**RE: SUB22-005 (Feng Preliminary Short Subdivision)
Request for Information #1
7204 78th Ave SE, Mercer Island, WA 98040**

We have outlined below our responses to your request for information on Short Plat Submittal with Number: SUB22-005. We refer to sheet numbers and noting to each item where the requested information can be found. Please let us know if you have further comments.

TREE RETENTION PLAN

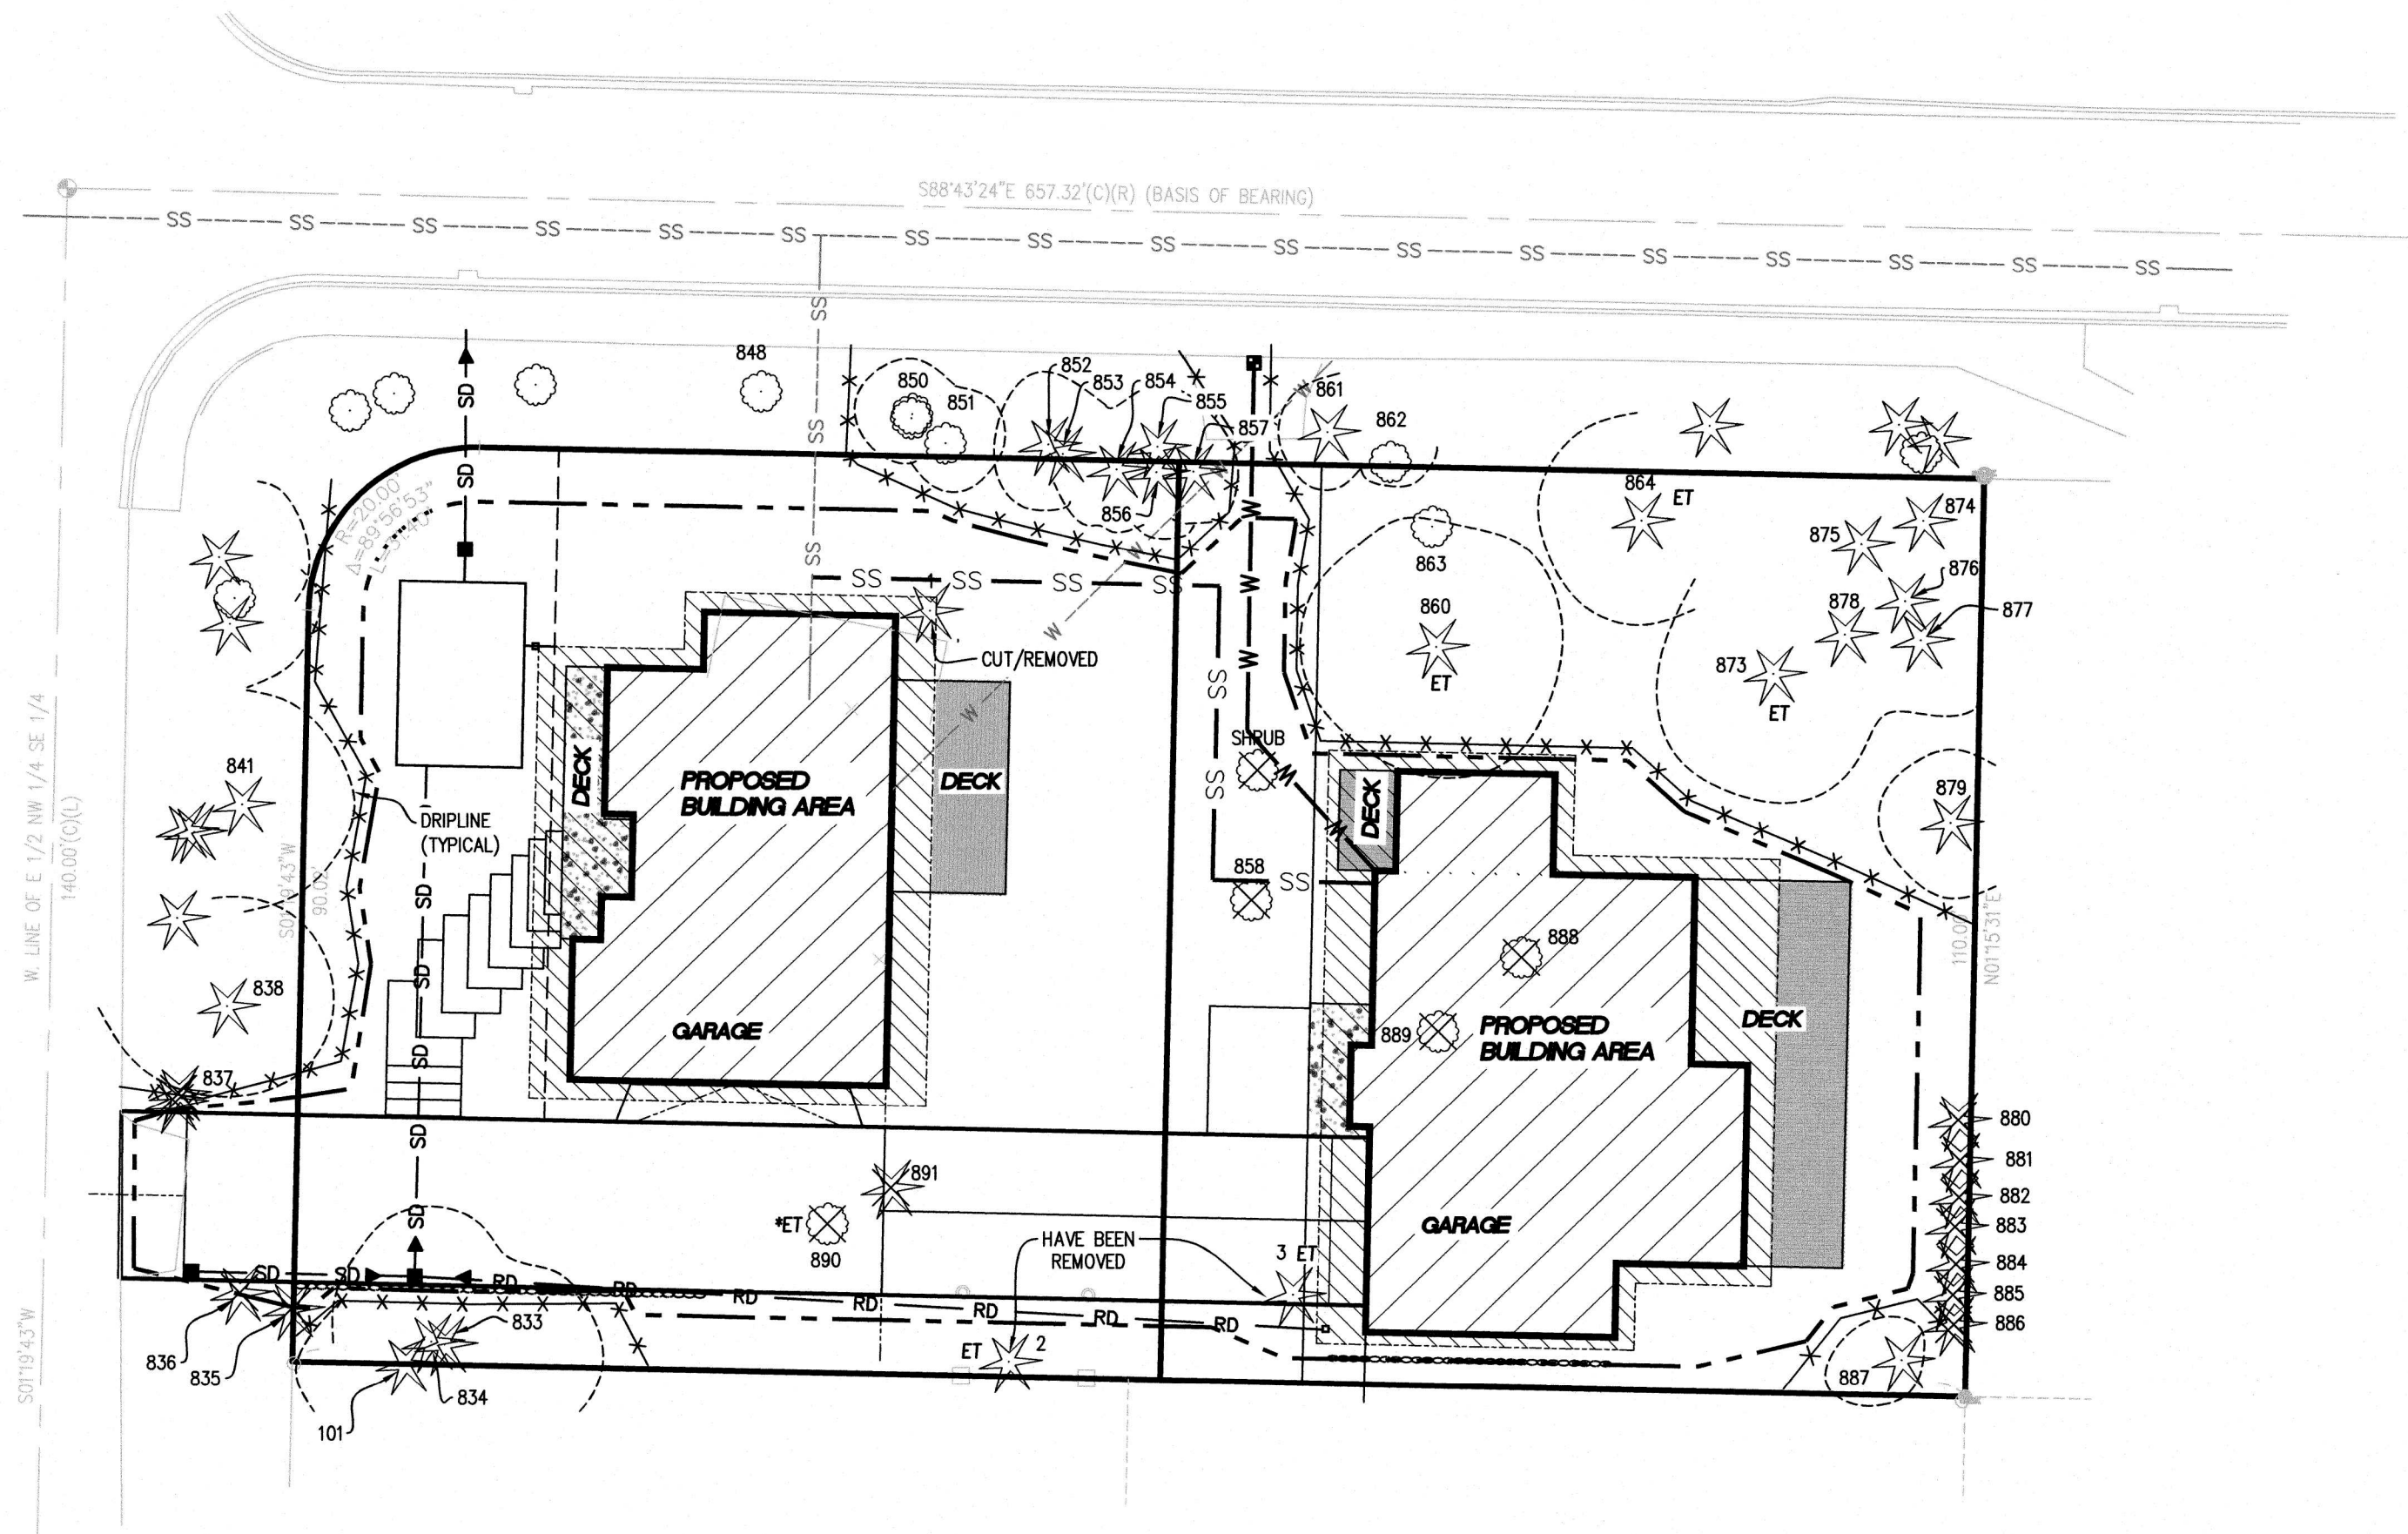
14. Exceptional tree 860 is proposed for removal and must be retained unless its removal is justified under MICC 19.10.060(A)(3).

Response: Exceptional tree 860 is changed to be retained, see Tree Retention Plan, sheet 7 of 9.

DWAY XSEC
SCALE: 1" = 20' H
1" = 5' V

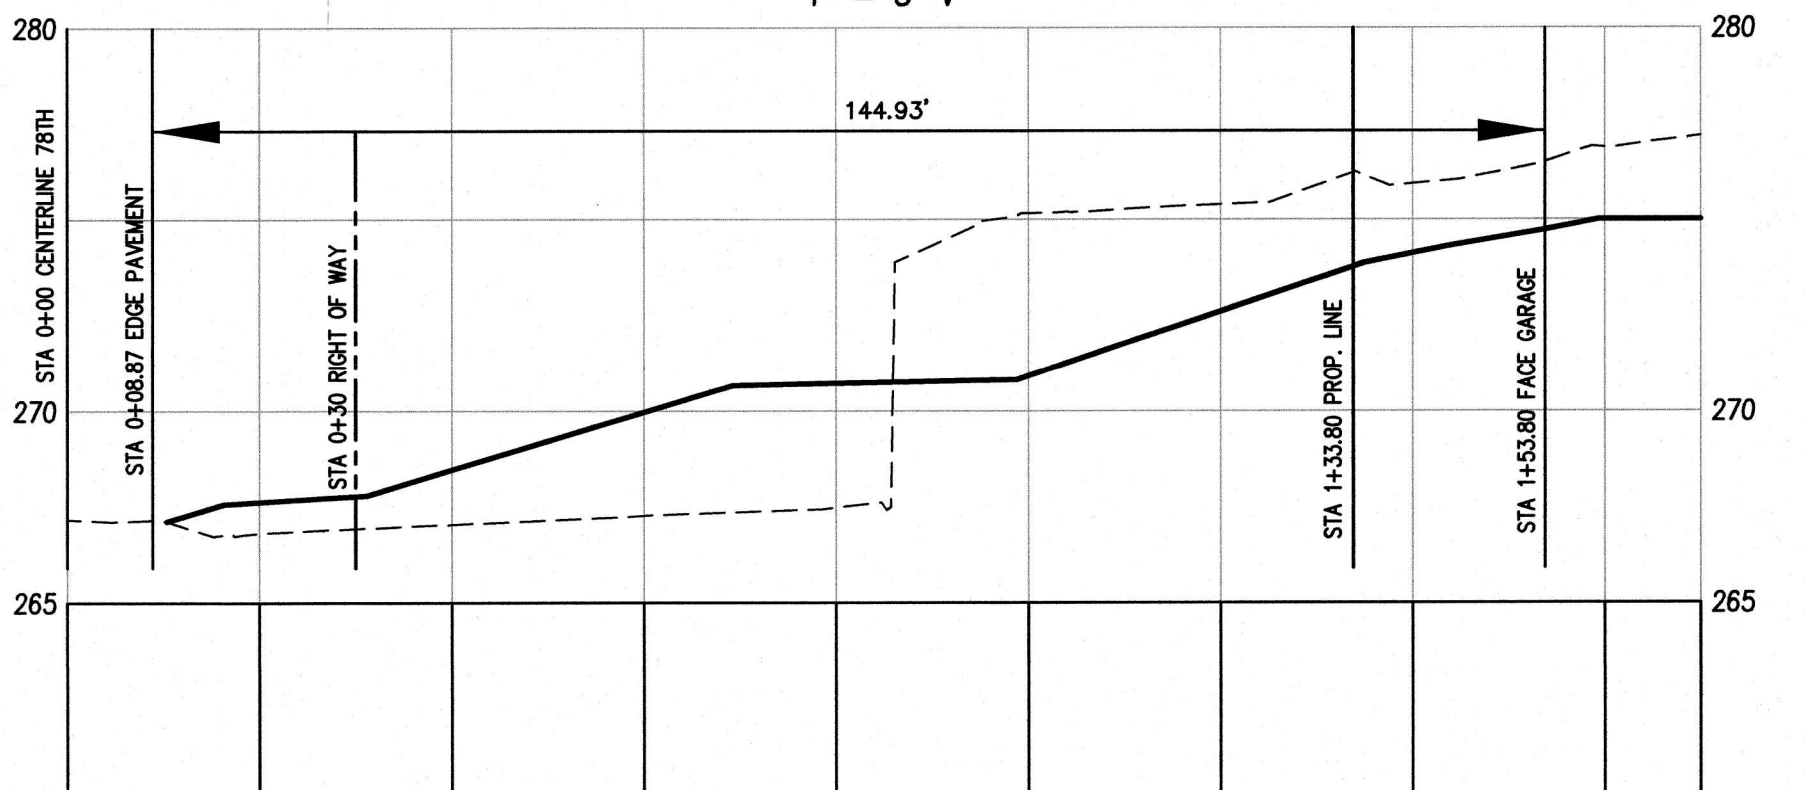
6. Please clearly distinguish all public easements from the private easements. The private utility easement and public utility easement shall not be combined.

9. The side sewer shall be shared by the two lots created by this short subdivision. No new connection to the city sewer main will be allowed for the additional lot.

13. The proposed building pads shown on the plans appear to require grading and utilities within the tree protection zone. Please revise the building pads to account for tree protection.

[Response: Requirements are incorporated in Conceptual Grading and Utility Plan, sheet 9 of 9.](#)

[Response: Requirements are incorporated in Conceptual Grading and Utility Plan, sheet 9 of 9.](#)

Response: Clearing limit is demarcated to avoid any grading around tree protection zone, this is demonstrated in the Conceptual Grading and Utility Plan, sheet 9 of 9.
